Our Ref: AB/112/21/DOC

Approval of details reserved by condition imposed under AB/4/18/PL relating to conditions 4-surface water drainage, 5-maintenance & management of surface water drainage & 7-Construction Management Plan.

1-7 Canada Road Arundel BN18 9HZ

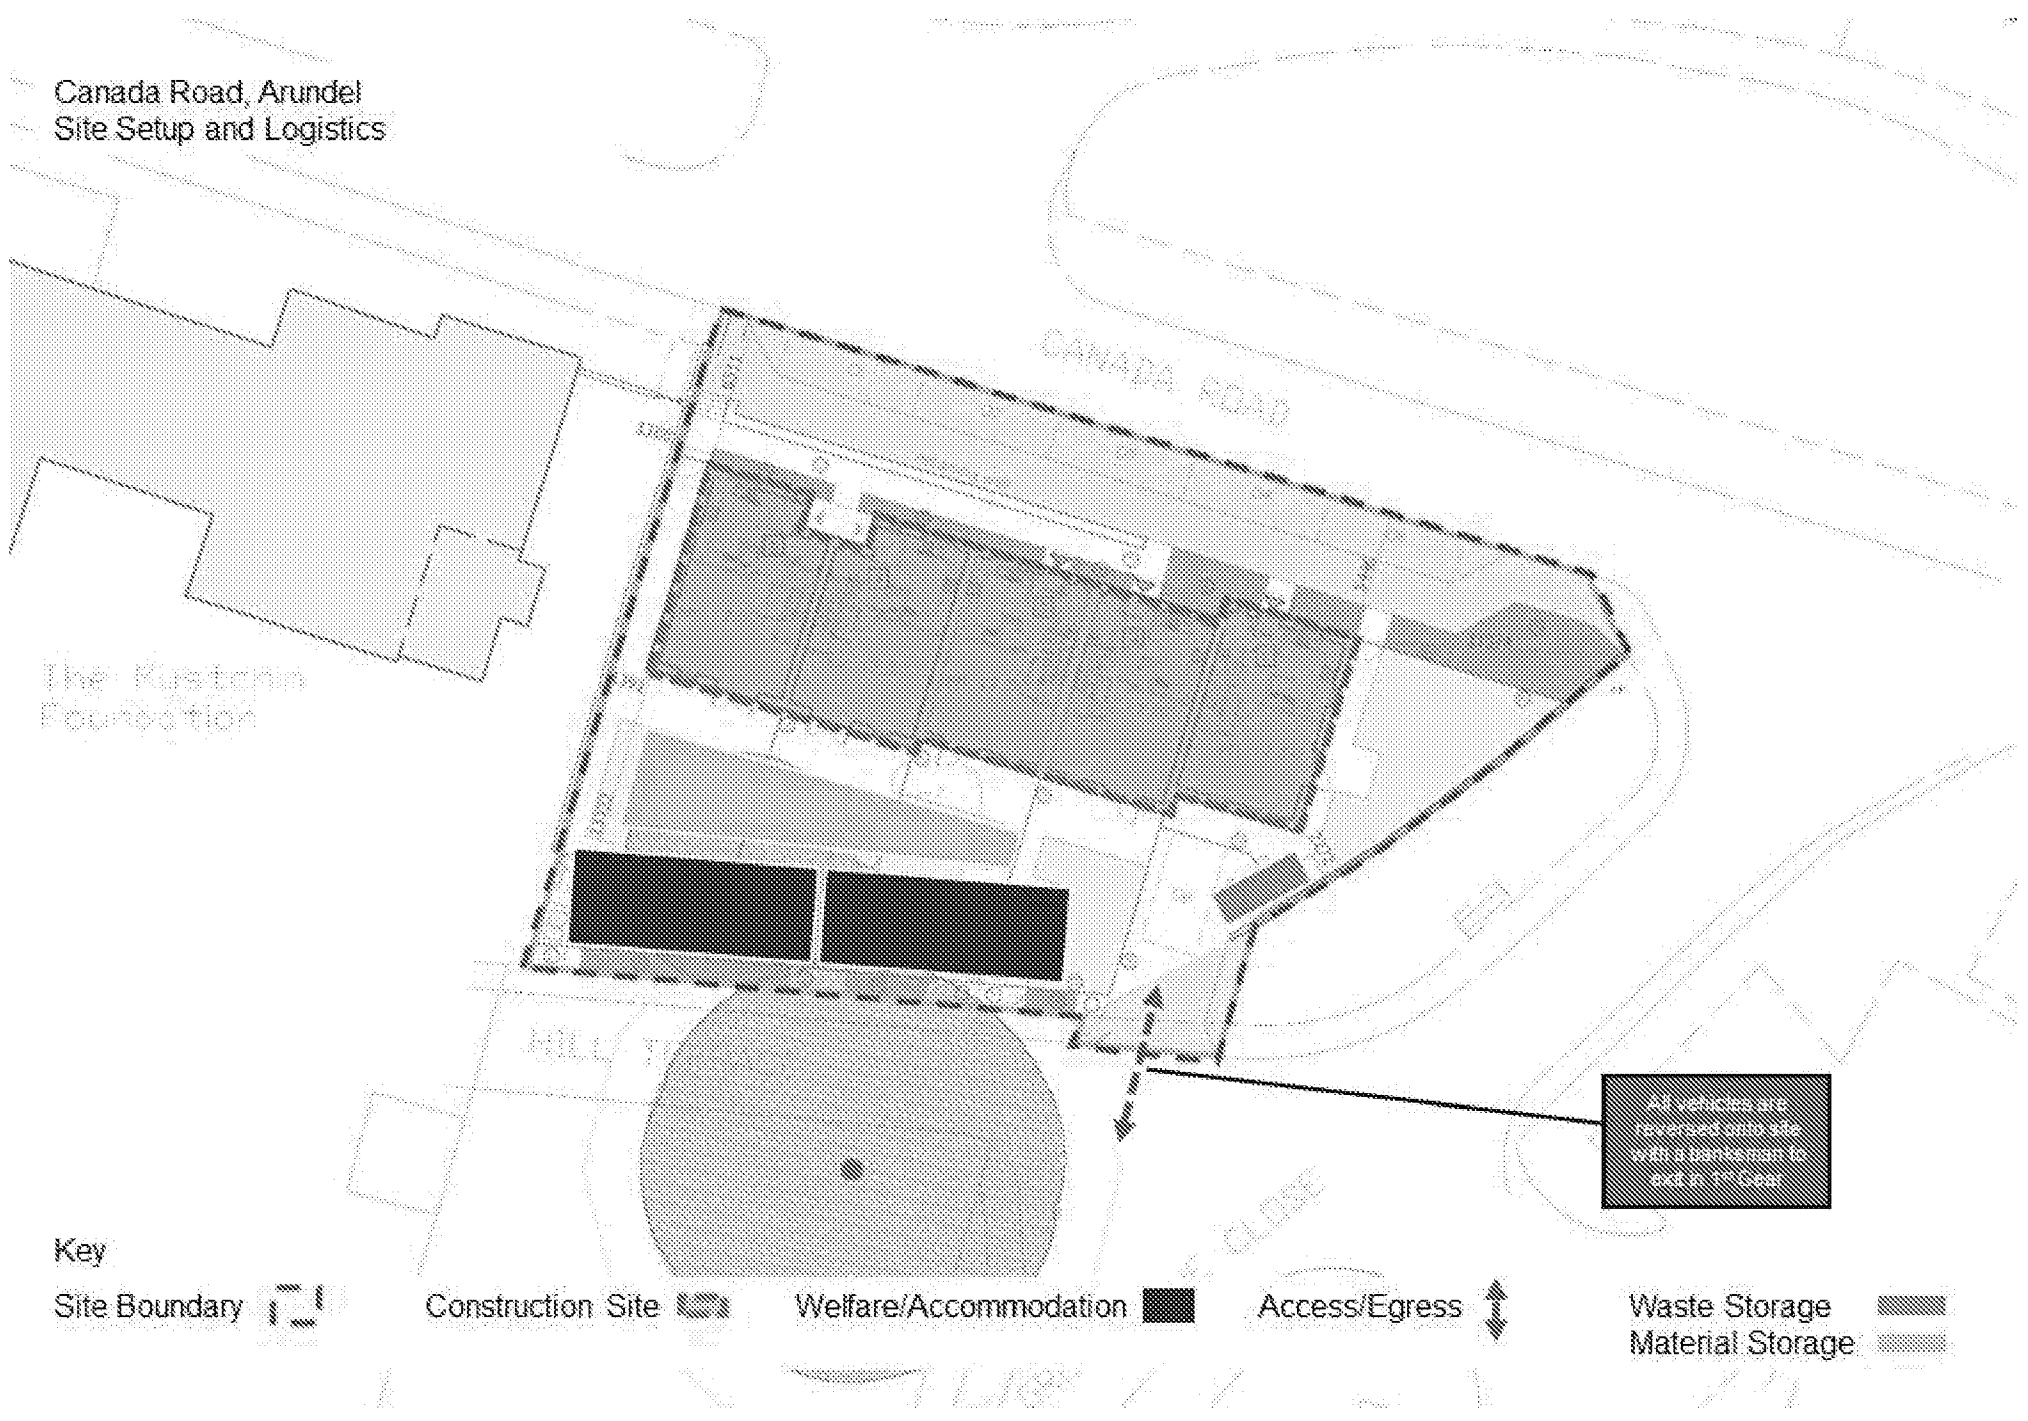
The submitted details do not include adequate details with regard to contractor vehicle parking the site map should include locations marked out for all sub-contractor buildings, location/s for plant and stacks of materials, area/s for loading and unloading of vehicles associated with the implementation of this development.
